2024/1061

The School Bungalow, Wentworth Road, Blacker Hill, Barnsley, S74 0QT

Demolition of existing garage and conservatory and erection of two storey extension and associated works.

title **PROPOSED ELEVATIONS**

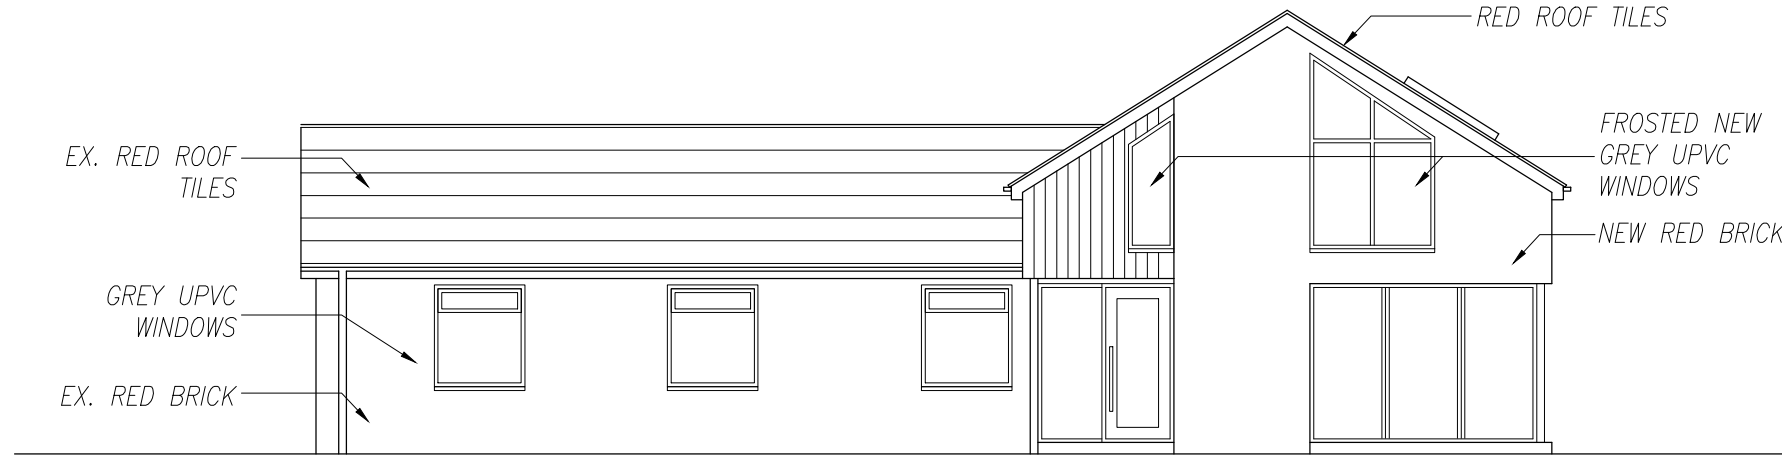
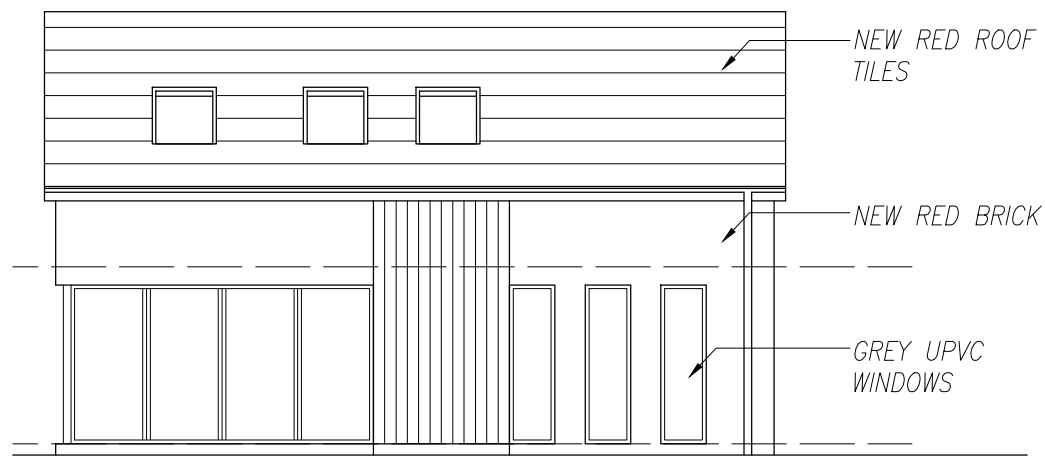
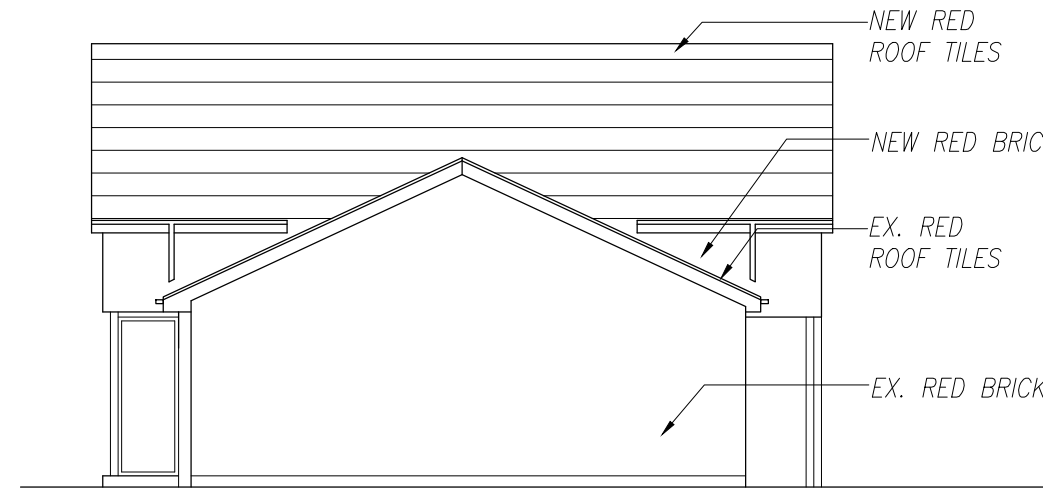
During the application process, the application proposal was amended to address the LPA's visual amenity concerns regarding the original design of the proposed extension as it would have appeared as an overtly dominant feature that would have significantly altered and detracted from the character of the existing building.

The amended development scheme proposes a much more balanced, considerate and sympathetic design that would lead to the appearance of a uniquely designed detached dwelling and would avoid having the appearance of a small, detached bungalow dominated by an extension. The submitted amendments are therefore welcome.

The proposed extension would adopt a small projection beyond the east and west-facing elevations of the existing dwelling with a relatively restrained footprint overall and would adopt a greater eaves and ridge height than the existing roof. Whilst an extension should not normally be as large as, or larger than the existing dwelling, it is considered that an overtly domineering appearance would be avoided in this instance. The amended development scheme is considered to provide an acceptable balance between the proportions of the existing dwelling and the proposed extension.

title **PROPOSED ELEVATIONS**

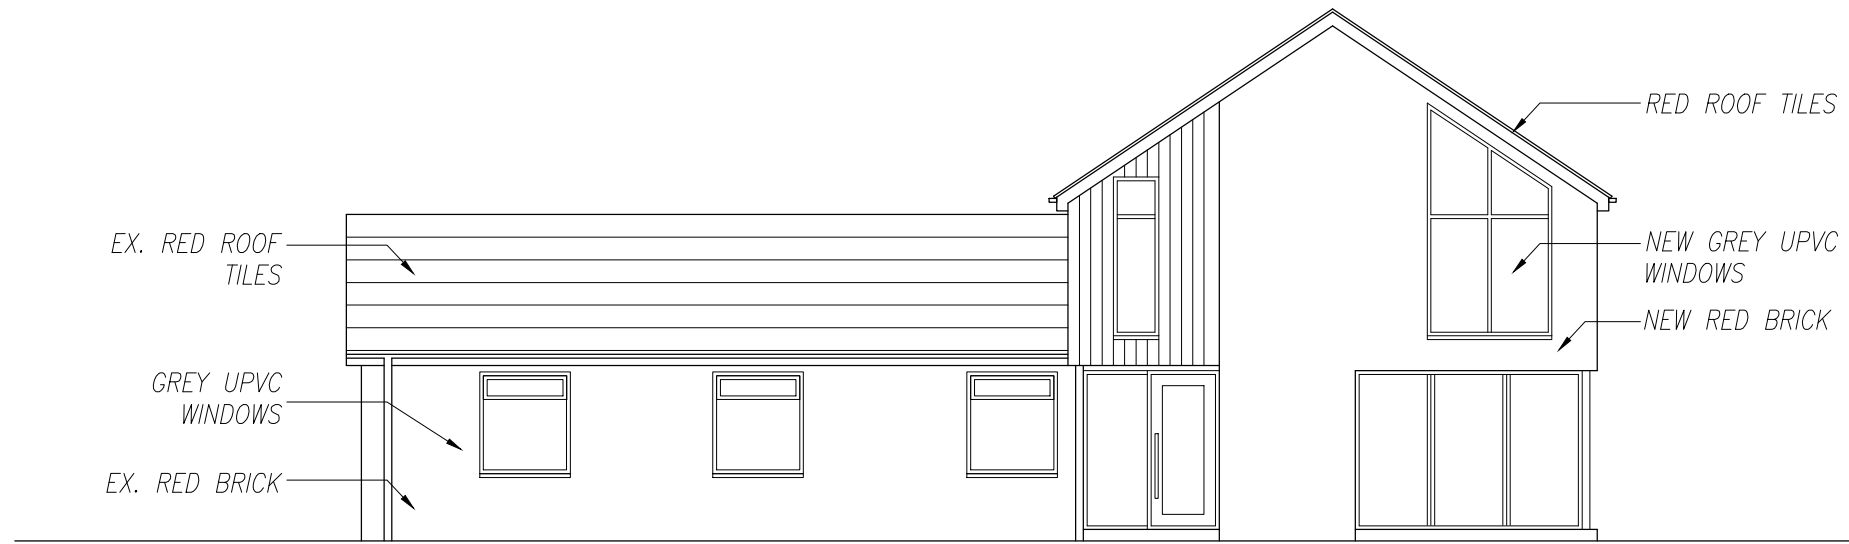
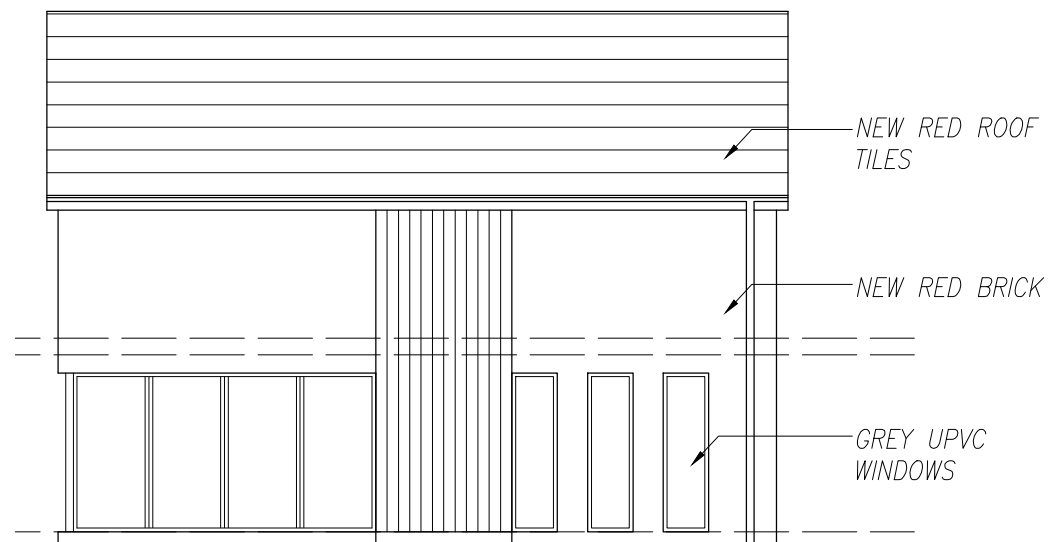
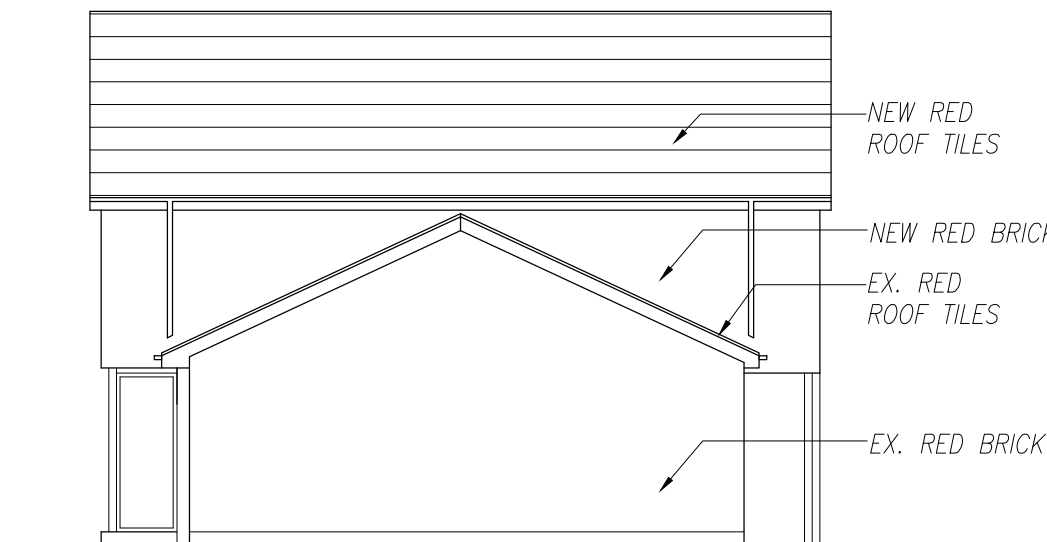
During the application process, the application proposal was amended to address the LPA's visual amenity concerns regarding the original design of the proposed extension as it would have appeared as an overtly dominant feature that would have significantly altered and detracted from the character of the existing building.

title **PROPOSED PLANS**

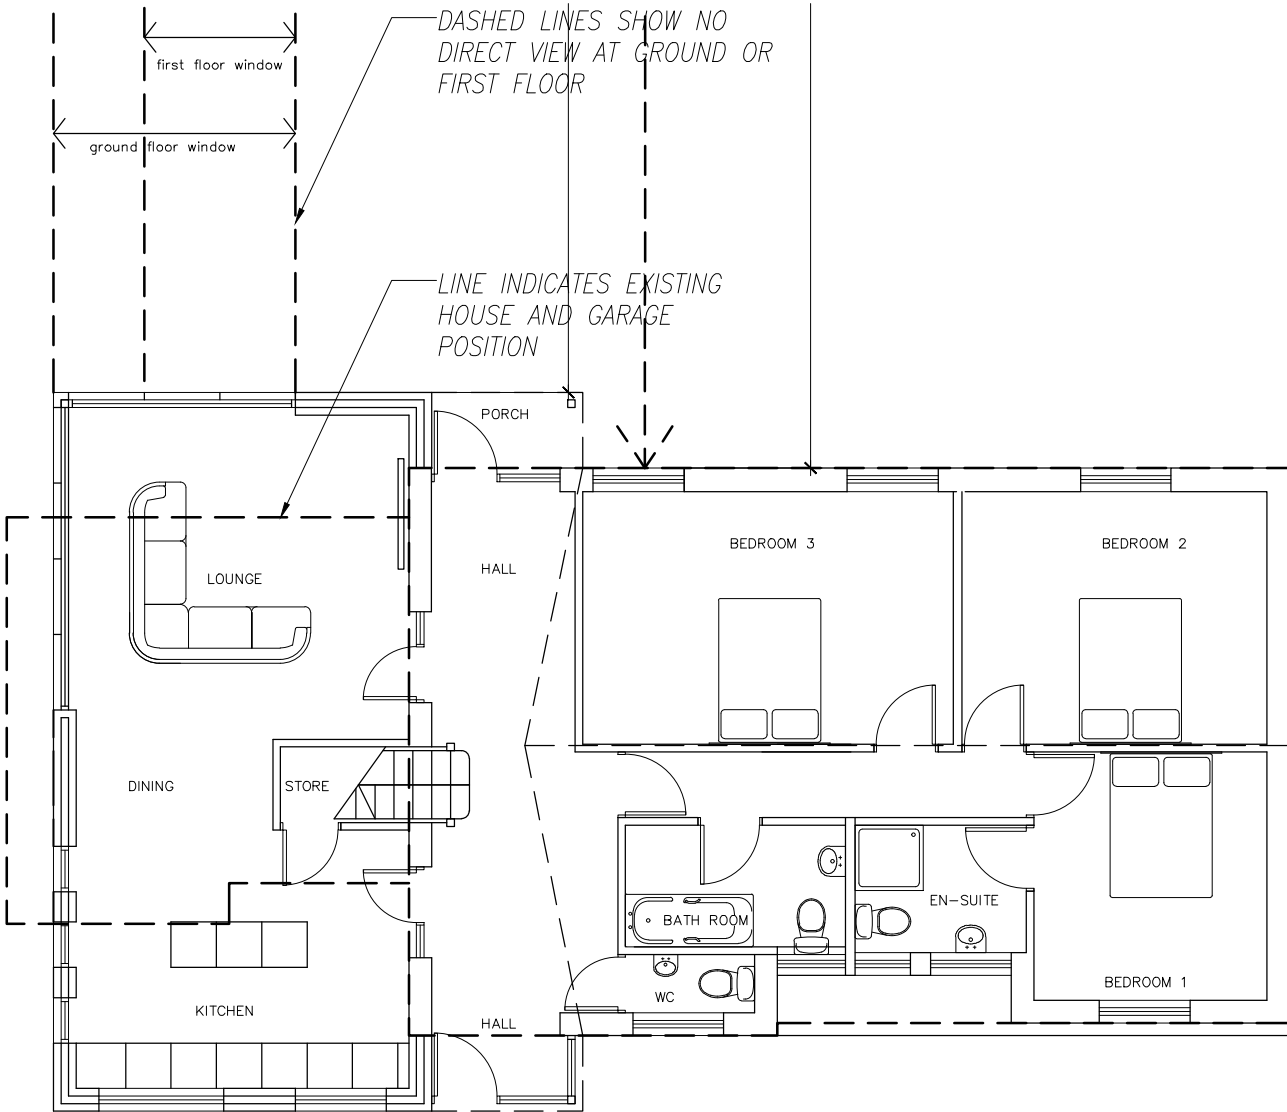
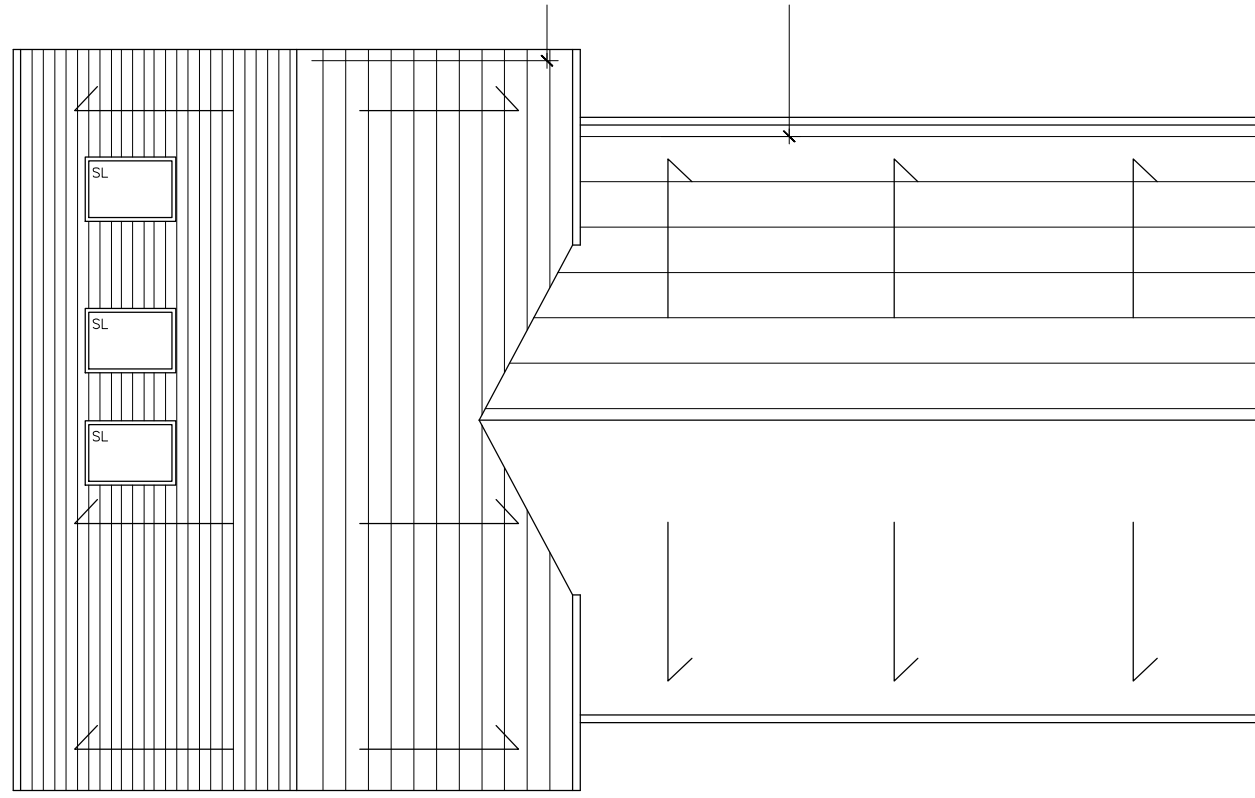
The proposed extension would feature extensive full height glazing at first floor level on the east and west elevations and at ground floor level on the south and west elevations. One new window would be located on both the east and west elevations of the existing dwelling and the existing separation distances between the existing dwelling, site boundaries and buildings beyond would be maintained. Whilst the proposed extension would maintain less than 10 metres to the east and west boundaries, contrary to the Council's design guidance, a sufficient separation distance (21 metres or more) would be maintained between the first-floor windows and the adjacent commercial building to the east. The proposed extension would also largely maintain existing separation distances on-site. A separation distance of approximately 18.6 metres would be maintained between the first-floor windows of the proposed extension and 101 Wentworth Road to the west, which is less than the desired 21 metres.

However, these windows would not directly face habitable room windows on the adjacent dwelling, would serve non-habitable rooms and are proposed to be frosted. As such, the amenity of any potential future occupants of 101 Wentworth Road would not be significantly detrimentally impacted by way of overlooking or loss of privacy. It is acknowledged that there is an absence of good quality boundary treatments on-site, and whilst none are indicated on the plans, the erection, construction, maintenance, improvement or alteration of a gate, fence, wall or other means of enclosure of up to 2-metres-high could be implemented on the north, east and west boundaries of the development site as permitted development without a requirement to obtain planning permission. The applicant has indicated that they intend to erect timber fencing using permitted development rights. This would likely provide the development site and surrounding plots with a reasonable degree of privacy.
